# CITY OF ALBUQUERQUE

August 9, 2013

**Re: El Dorado High School  
Drainage Master Plan (G22/D004)  
Engineer's Stamp Date N/A**

SHEET TITLE
**PROPOSED CONDITIONS
BASIN MAP**
SHEET NO: **FIGURE 10**
PAGE 24

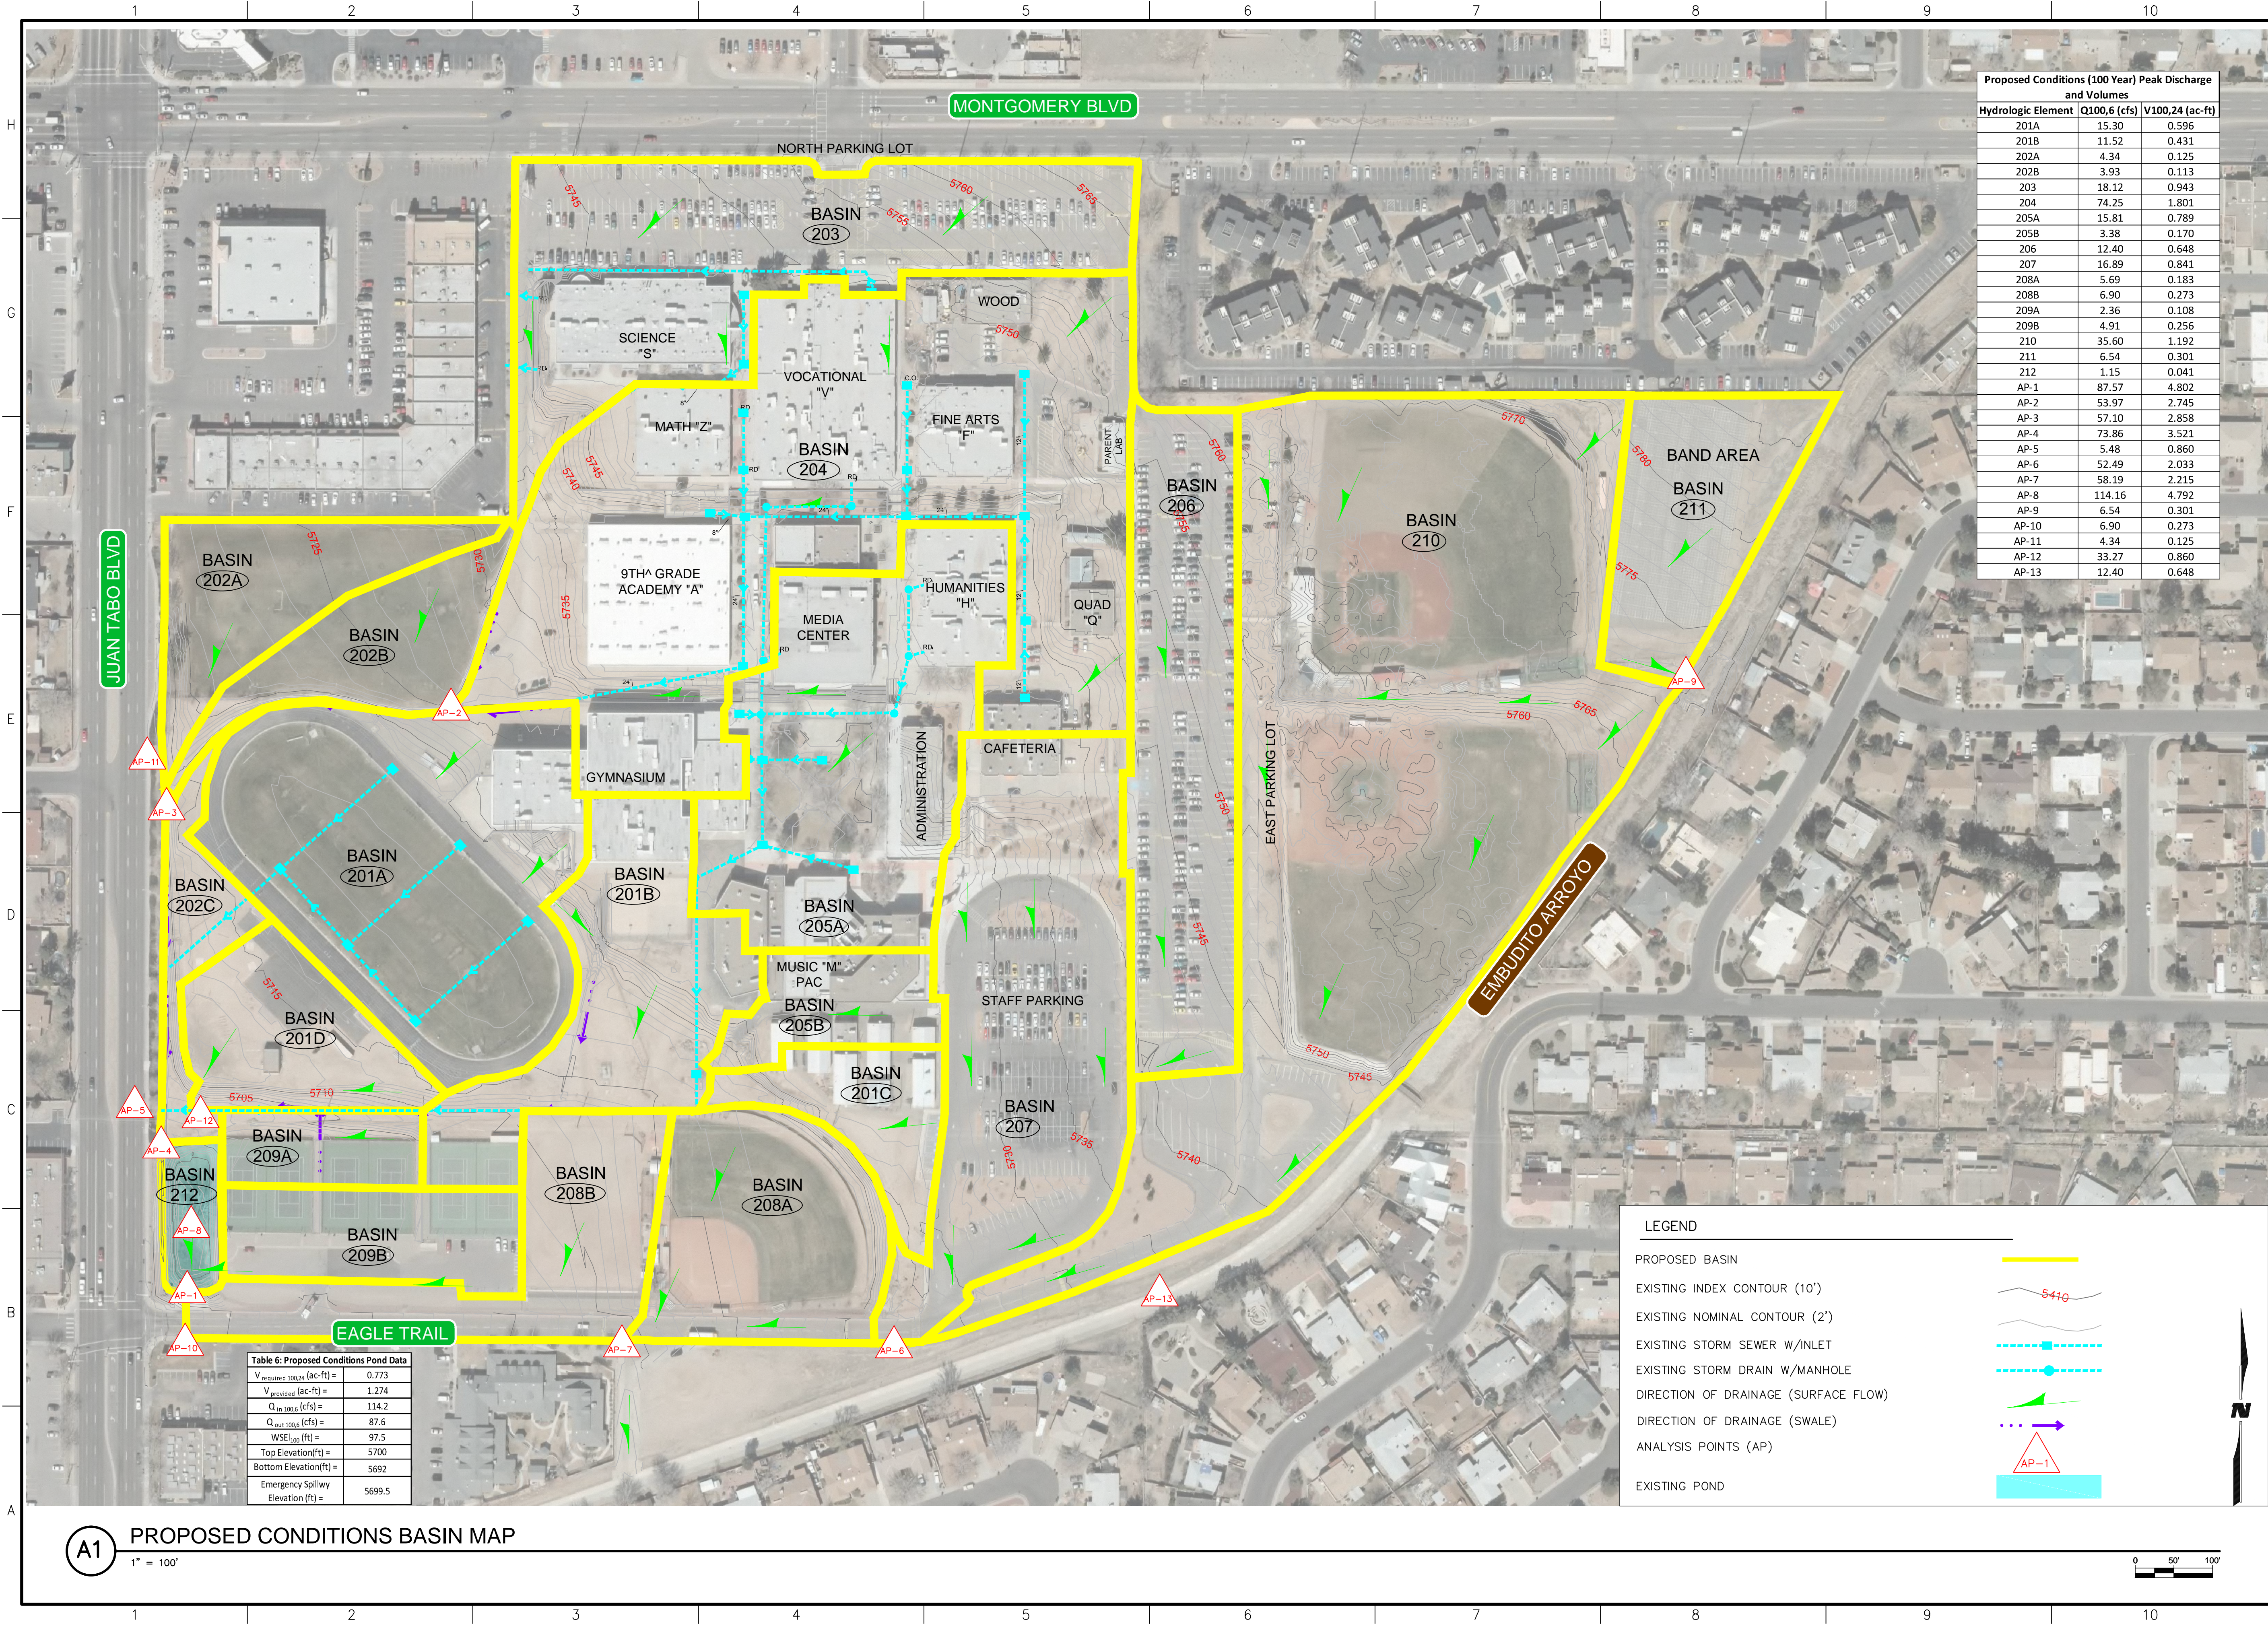
- Are there any offsite runoff entering the site? Is there adequate water block at the entrances?
- What is the land treatment for Basin 112/212? This basin was not included in the AHYMO calculations.
- Please provide large size maps including the basin table, analysis point, and storm drain structures.
- The legend under Figure 8 does not include all the improvements shown on the map and Section 4.5. We recommend that 2013/2015 improvements and future improvement to be shown on two different maps.
- Please provide engineer's stamp on the report and the plans.
